Portishead Branch Line (MetroWest Phase 1)

9.15 ExA.CAH1.D3.V1 – Applicant's Oral Case and response to Representations at the Compulsory Acquisition Hearing 1 (CAH1)

The proposed Portishead Branch Line (MetroWest Phase 1) Order

Applicant's response to Representations at the Compulsory Acquisition Hearing Held on 4 December 2020 at 10am

Drawing
PORTISHEAD STATION CAR PARK
LAYOUT, LANDSCAPING AND NEW
BOULEVARD AND ACCESS PLAN
SHEET 2 OF 3

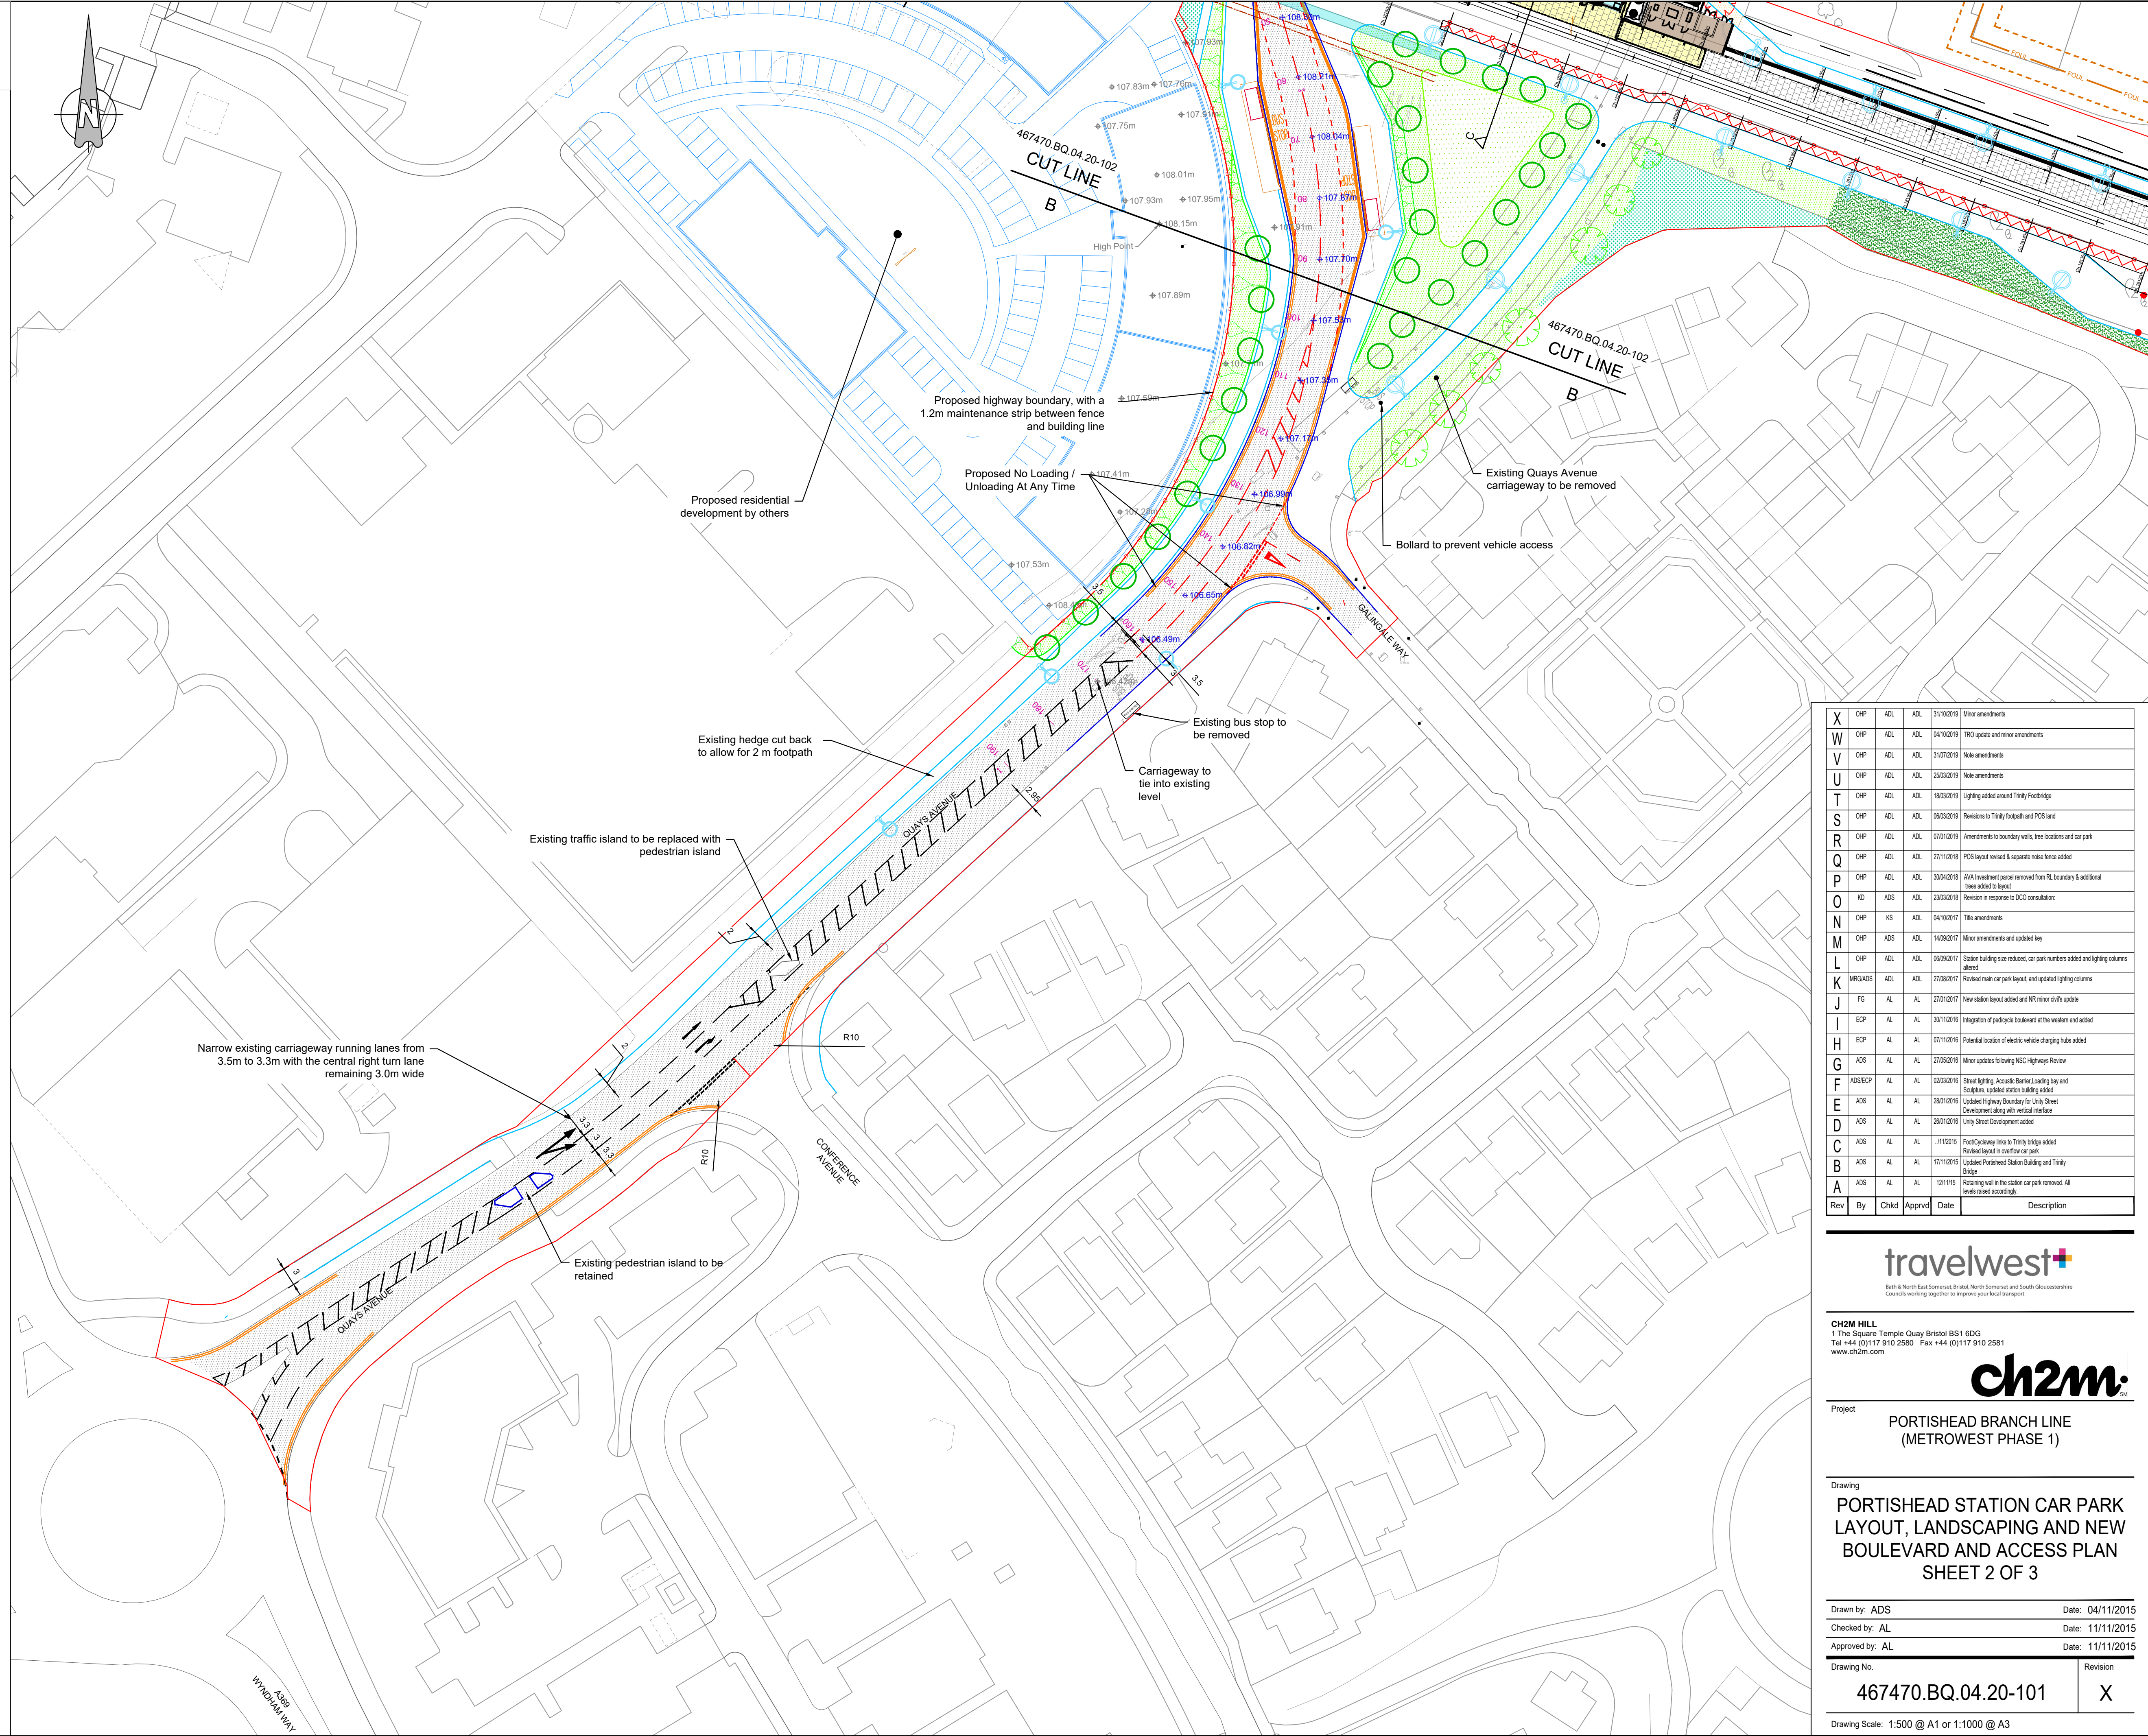
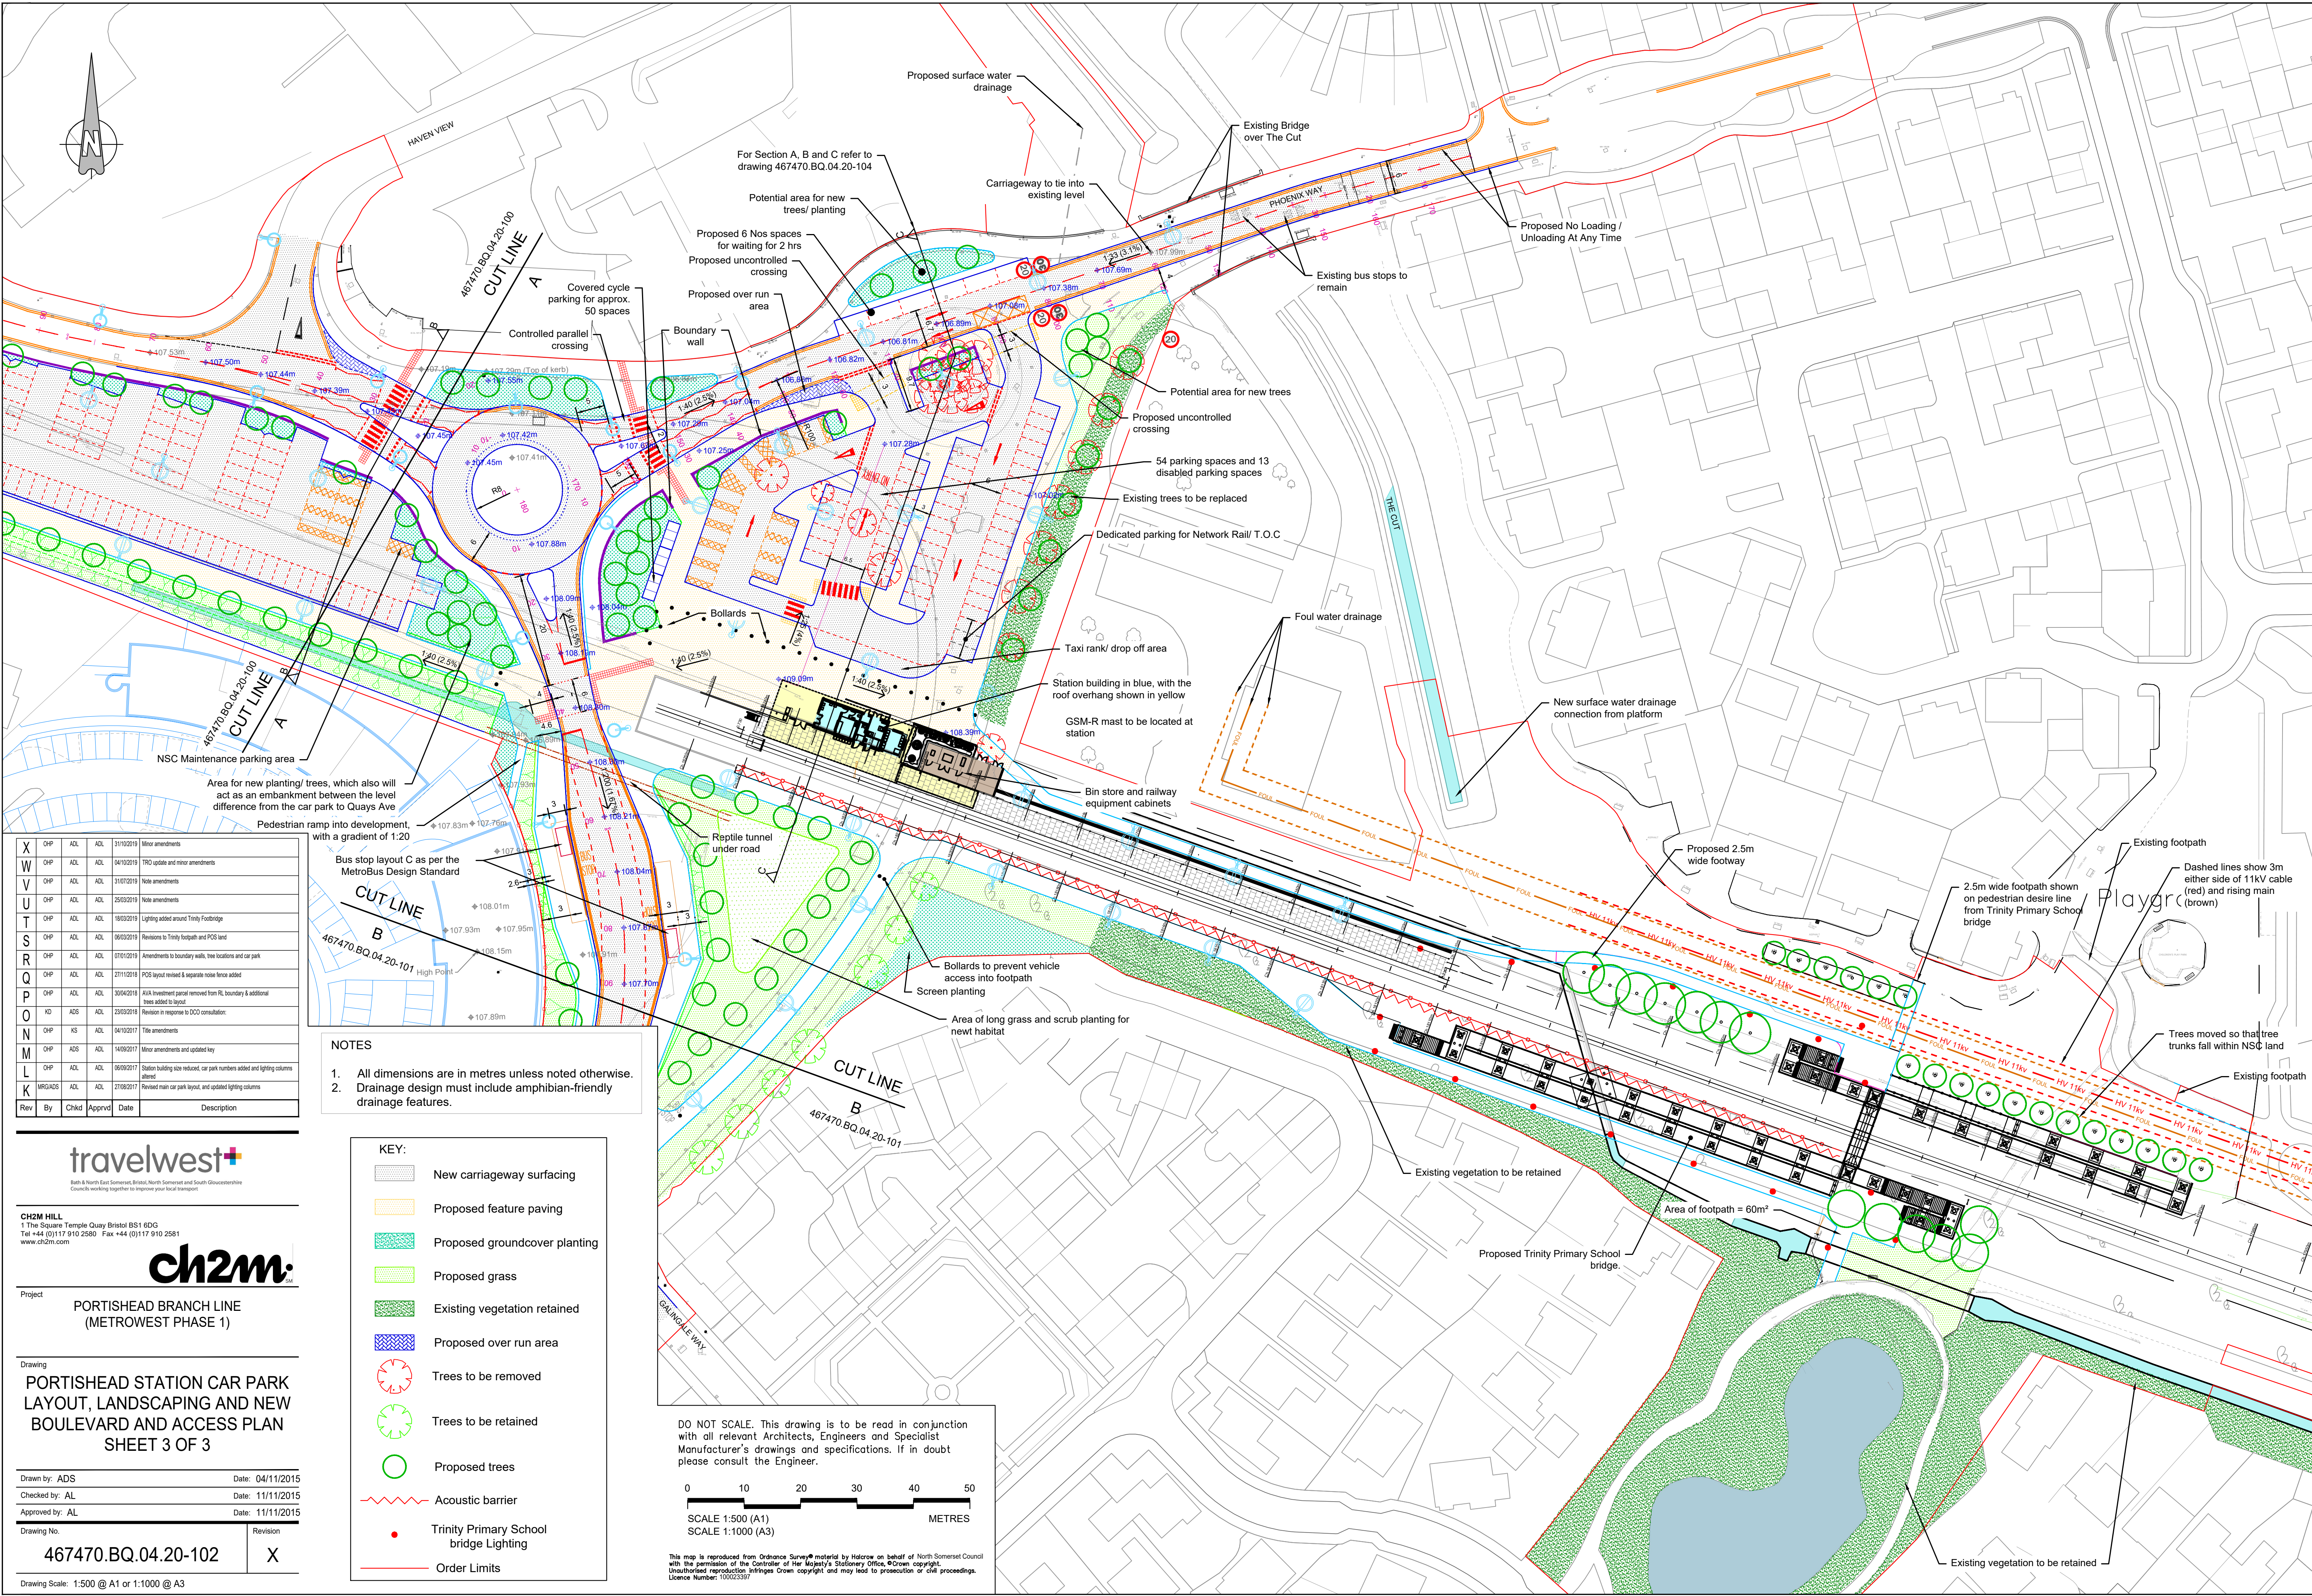
Ref:	Question/ Representation by:	Questions/Issues Raised at the CAH	Applicant's Response at the CAH	Applicant's Written Response
			to rule out some degree of management of the routes that are taken by the public, dealing with informal permissive right across the railway. Access would be by foot only The new rights being sought (01/252, 01/255,01/260 and 01/270) is to access the freehold land (01/299) that runs south from the railway and which is to be used for ecological mitigation purposes. The new rights and freehold land will not itself give an alternative route for access or re-routing public access. The Applicant added that in that area, additional street lamps are to be provided and a small amount of plant is required in order to install the street lamps. In addition, the open space may be scheduled to come over to the Council in any case as part of a historic s106 agreement.	already present in this pond so it is reasonable to be able to access this pond to allow safe release of GCN and other amphibians found within 1 km of the pond (it can only be for release of amphibians found within 1 km of the pond to avoid the need for disease screening for chytrid fungus, which can affect amphibian populations). In relation to the street lamps, the Applicant would like to clarify these comments. Street lamps were due to be installed in this area under a previous works design. Following design review it was decided that the street lamps would not be installed.
